Response to Planning Application

Application ref: CM/53/20/PL

Description: Development of 2 No 2-bed & 2 No 3-bed detached dwellings & associated works. This site is in CIL Zone 3 and is CIL Liable as new dwellings.

Location: Land at Wren Cottage Horsemere Green Lane Climping BN17 5QZ

SITE PLAN
SCALE 1:500 @ a3

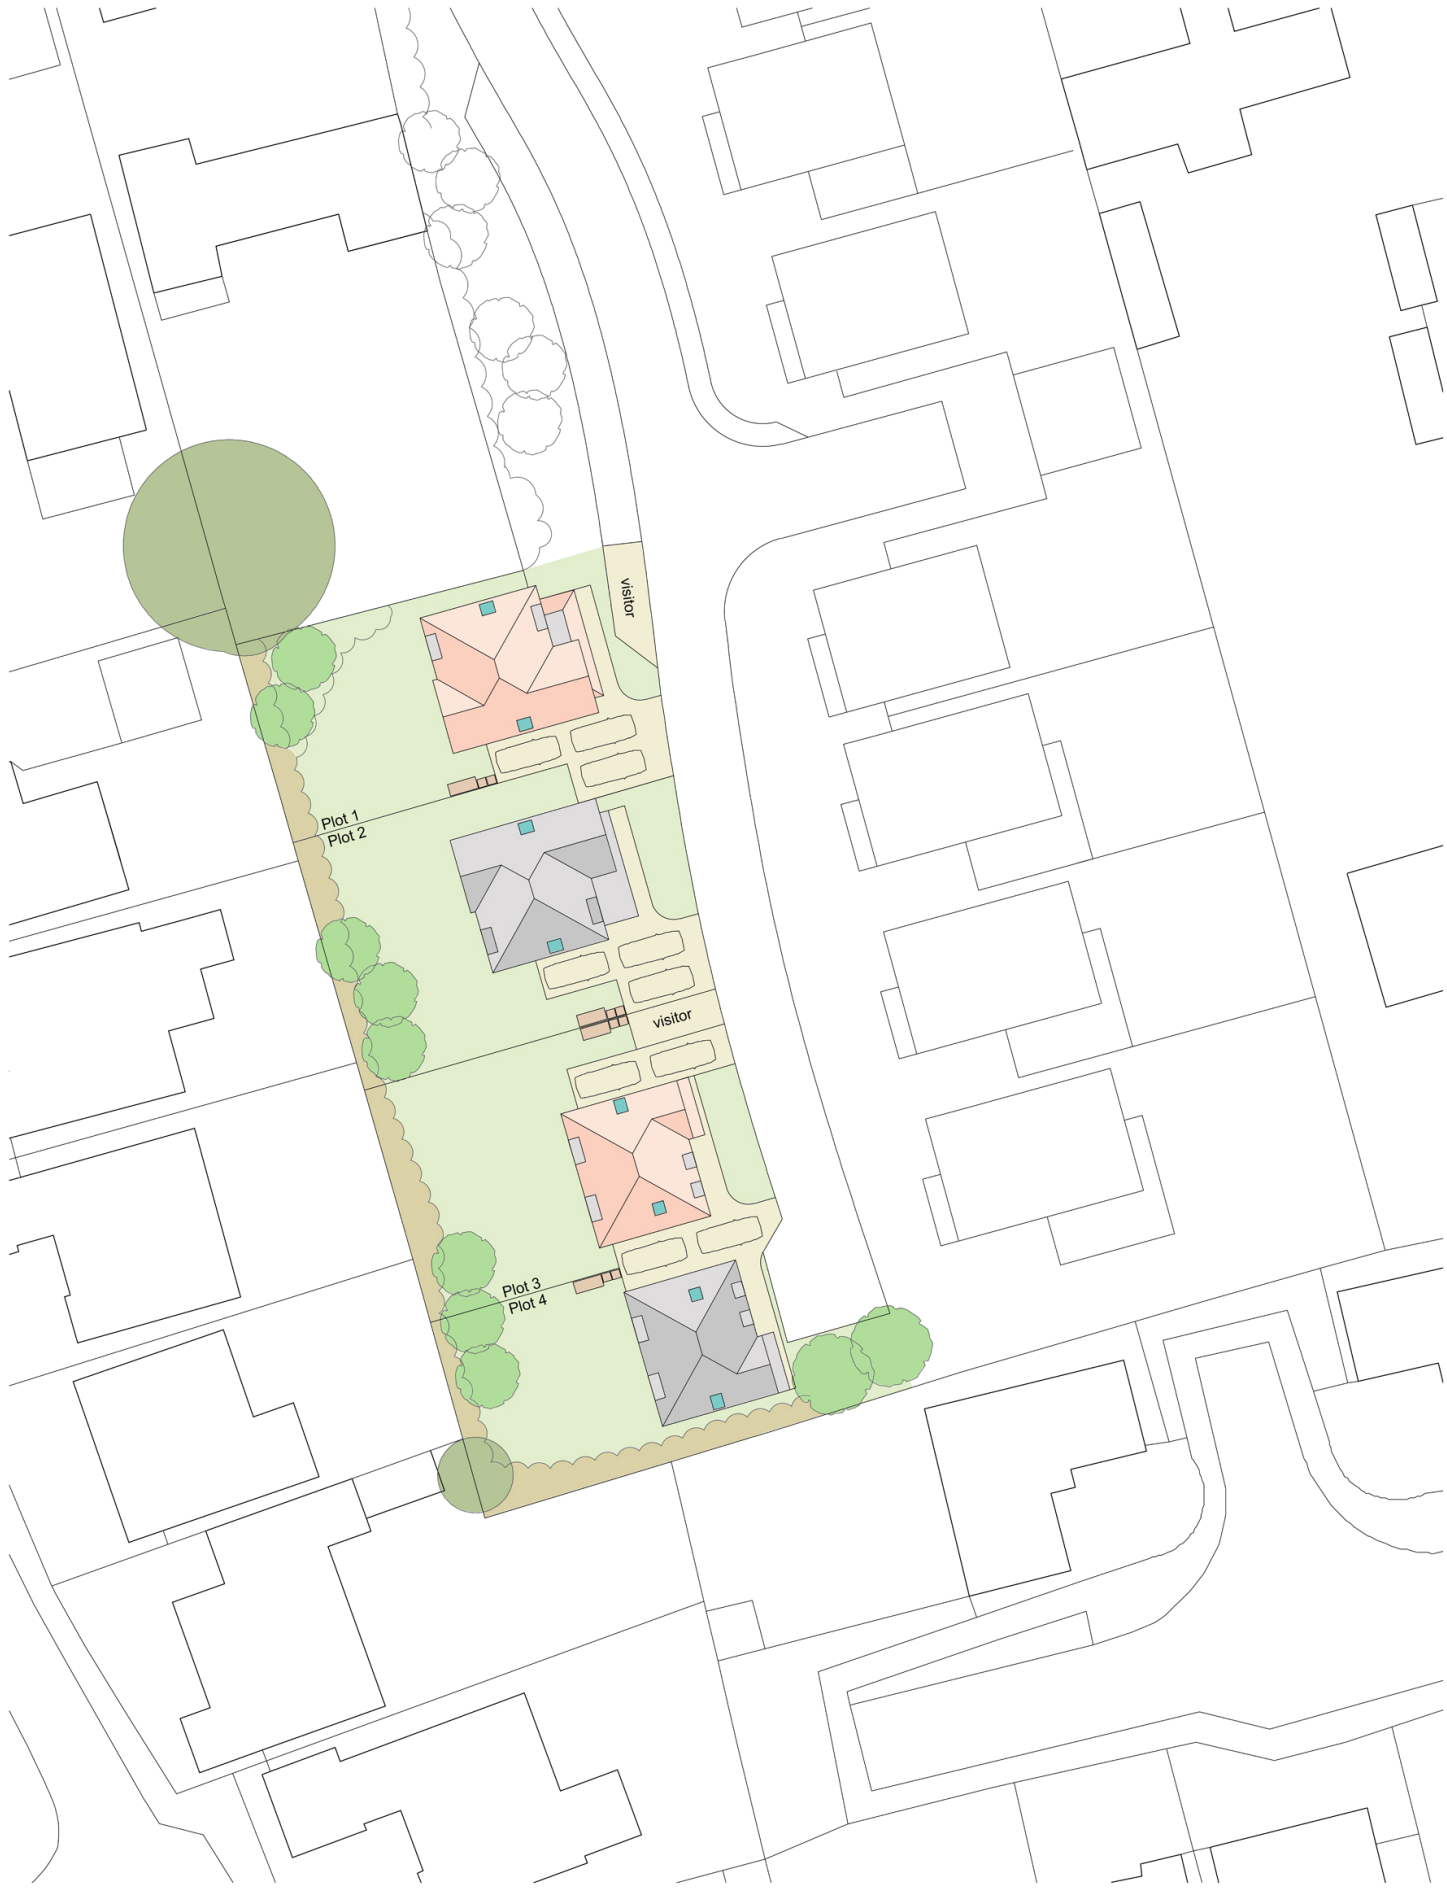
The NPPF para 124/127 relate to good design principles. The indicative location plan has suggested the retention of existing vegetation and inclusion of new landscaping to this development which would be required to be submitted and approved. The inclusion on new landscaping for these proposals should be in consideration of greening and screening and should also consider the biodiversity net gain requirements to be achieved with this development.

The potential impact of the proposals could be blended into the surrounding environment with further thought given to the landscape offer and greening to counteract this. Screening to adjacent properties will need to be considered because of their proximity and stature in relation to the proposals.

Further landscape provision to the roadway and accessible areas and incorporation of screening to adjacent properties with the incorporation of planted areas for trees and shrubs. The green boundary treatment to include tree species. All areas should be considered and their connection for biodiversity and habitat explored. Trees specified should be at a size which allow instant impact, but which will establish and mature as the site develops.

I would recommend **no landscape objection** subject to the submission of a detailed landscape scheme. Landscape detail to be submitted in plan form to show existing to be retained and new planting detailing species choice, actual quantities, planting densities and size at time of planting.
